Our Ref: 22/0714/FUL

INVALID APPLICATION

PROPOSAL: ALTERATIONS AND ERECTION OF EXTENSION TO EXISTING FACILITIES BUILDING TO FORM FACILITIES BUILDING INCORPORATING RETAIL AND RECEPTION AREA AND PAGODA SEATING TERRACE
LOCATION: Barnsoul Caravan Park, Irongray, Dumfries

PLAN

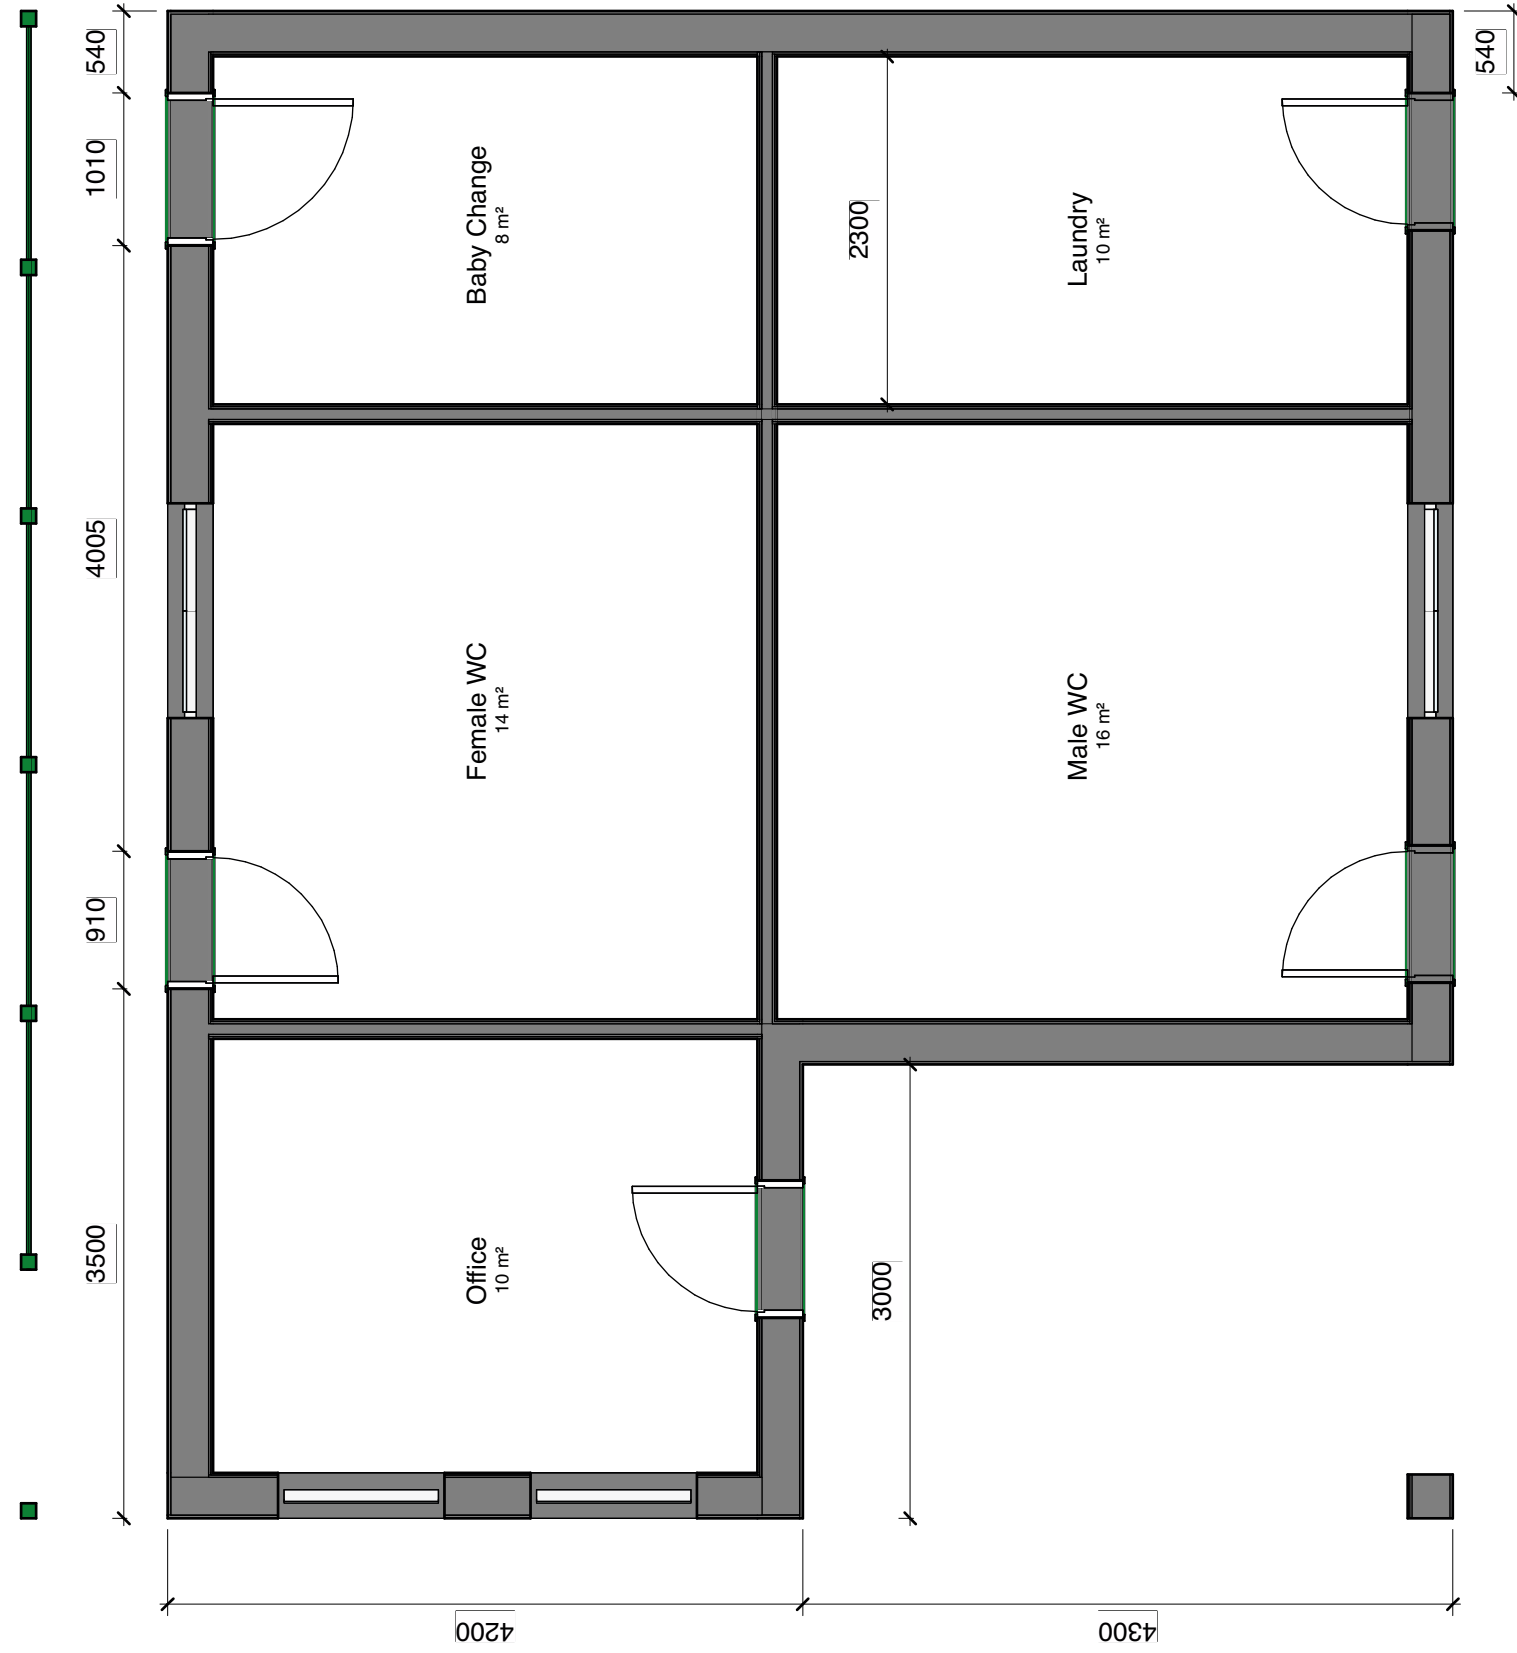
- 01. You have omitted to complete the site address on page 3 of the submitted planning application form. Please, therefore, complete the site address in the boxes provided or alternatively if there is no postal address please, identify/describe the site in the box provided below and submit an amended form as soon as possible.**
- 02. Please submit existing elevation drawings for the facilities building, drawn to a recognised metric scale of either 1:50 or 1:100.**
- 03. Please submit an amended version of your proposed floor plan with the**

dimension of the length and width of the proposed extension and the length and width of the covered pergola area. This will enable us to check the fee calculation.
